**PROPOSED CONNAH'S QUAY LOW CARBON POWER PROJECT**

**PLANNING INSPECTORATE REFERENCE: EN01066**

**RE: NATURAL RESOURCES WALES' WRITTEN SUBMISSION FOR DEADLINE 2**

Figure 13-1

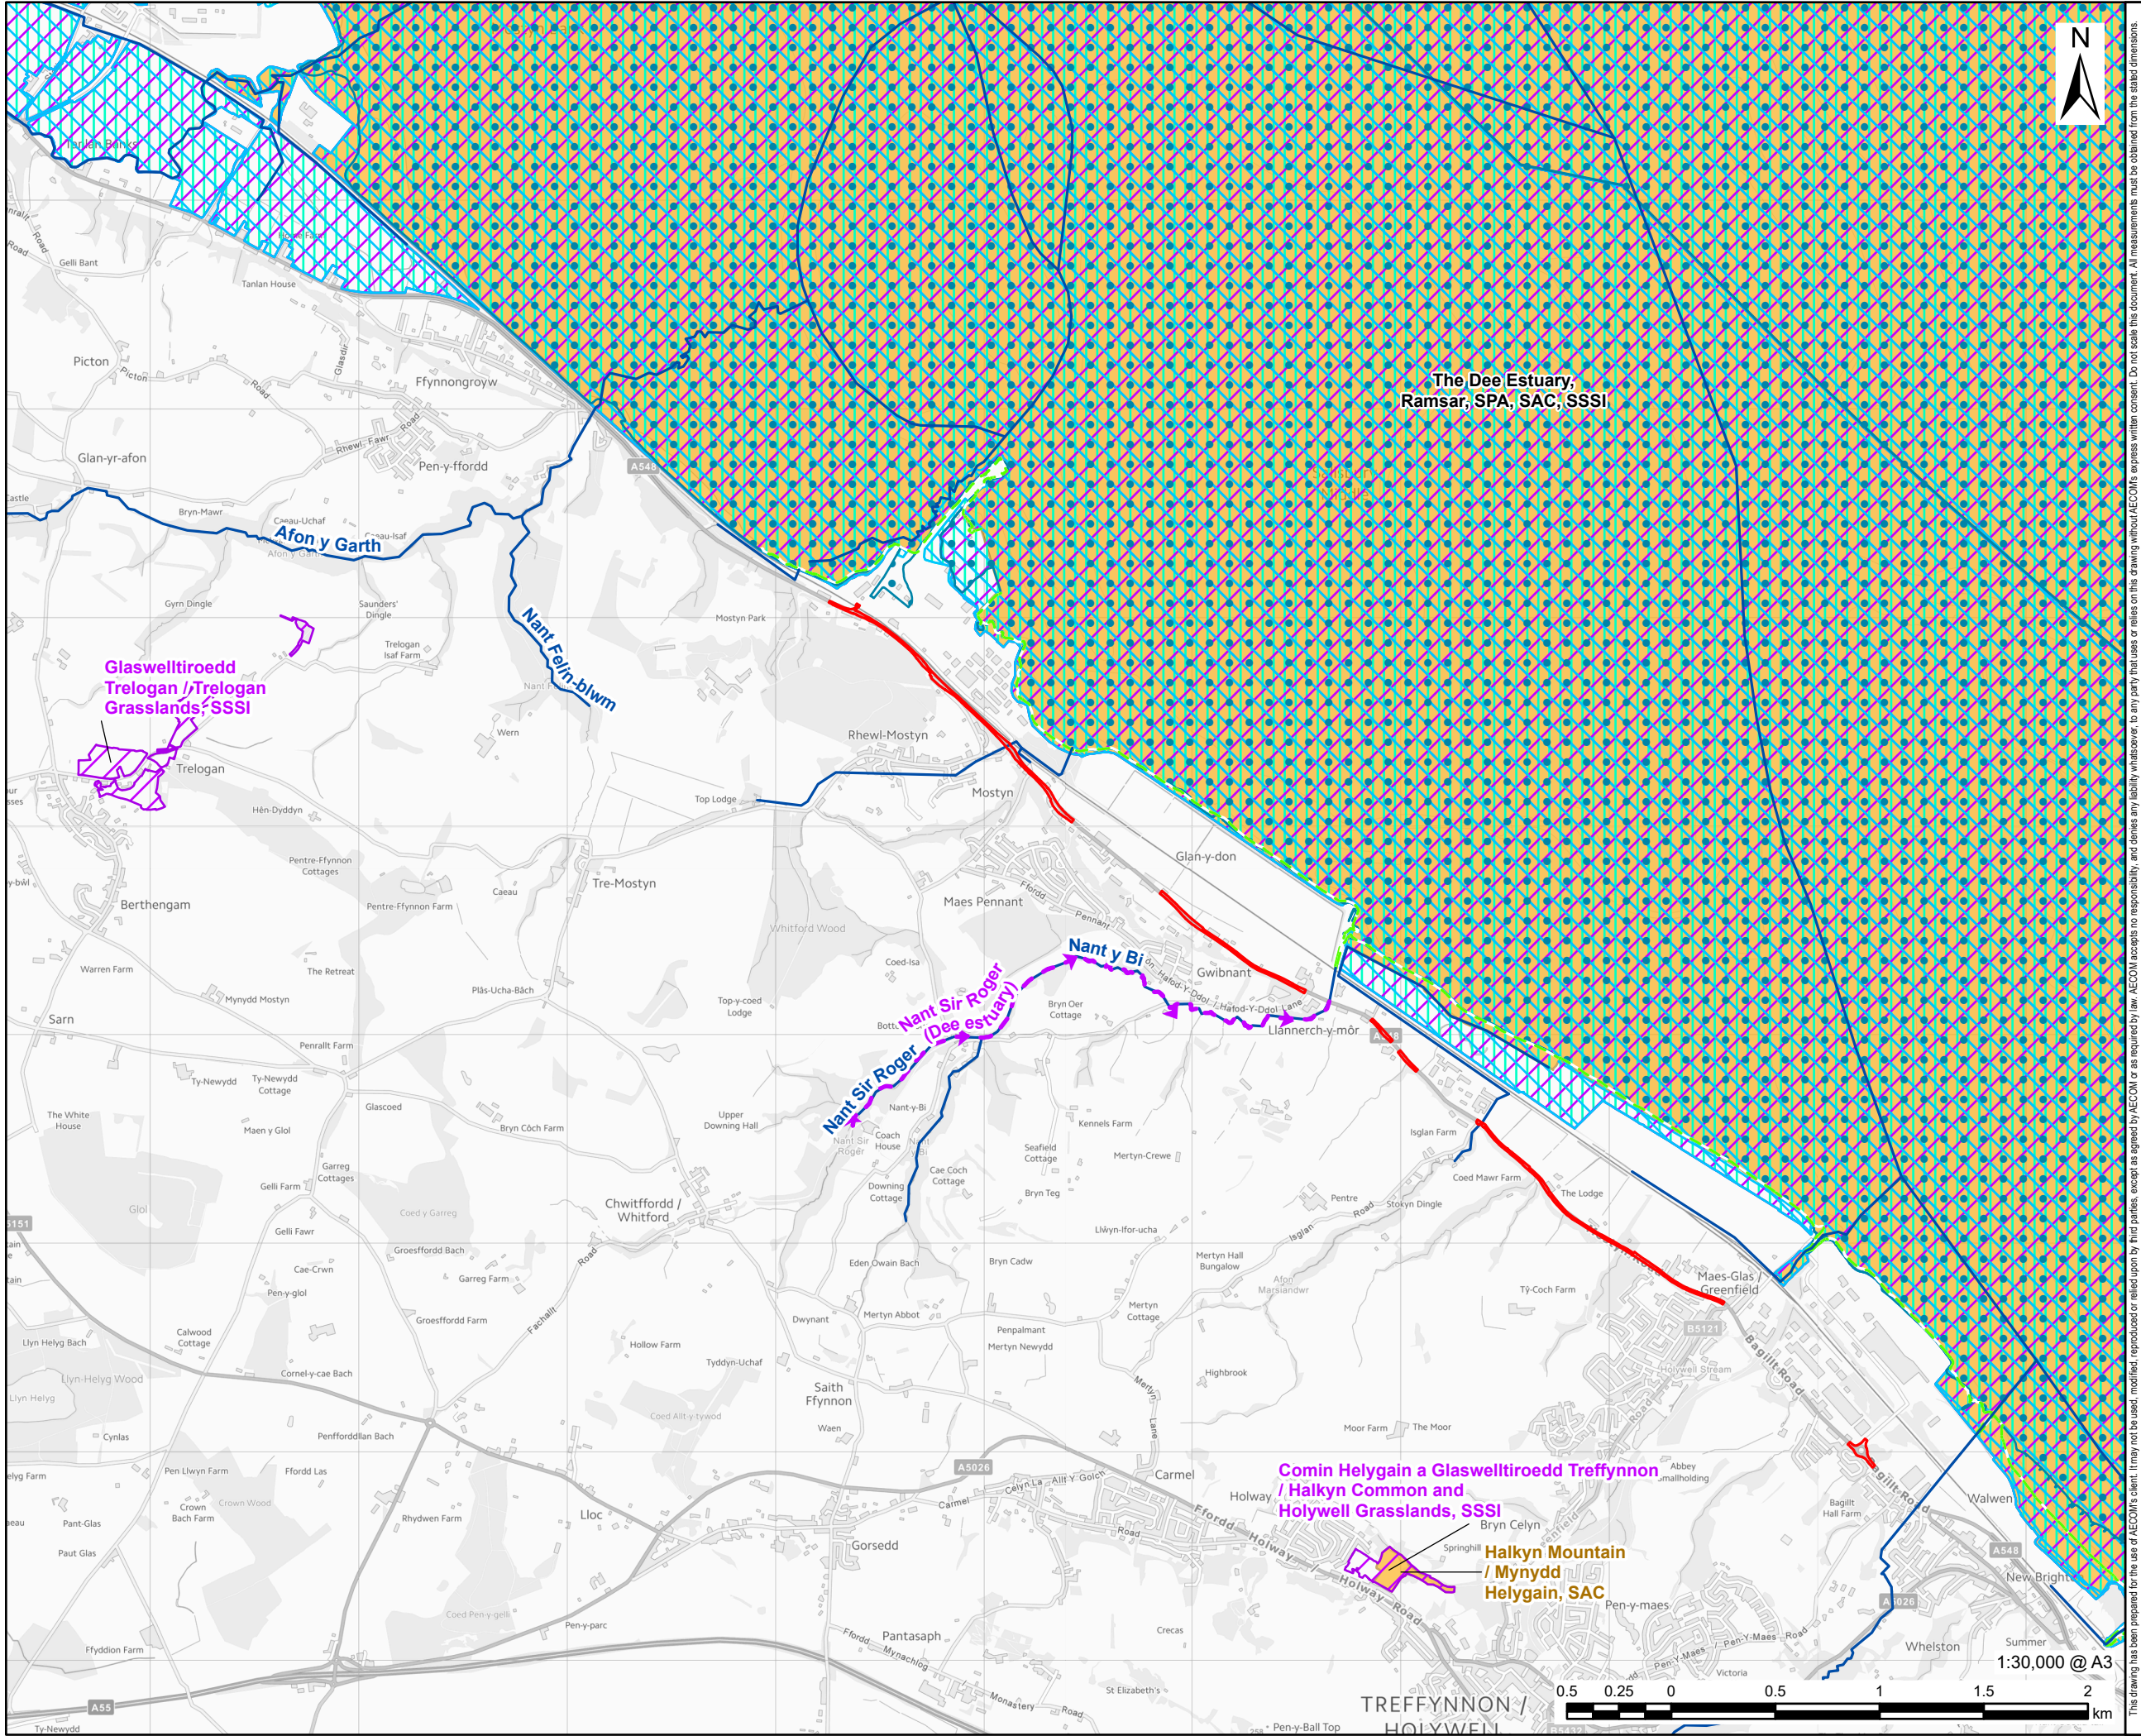
We note and welcome that Figure 13-1 has been updated to include the screened-out Water Framework Directive water bodies, namely Wepre Brook and Nant Sir Roger (Dee Estuary). We therefore have no further concerns regarding this matter.
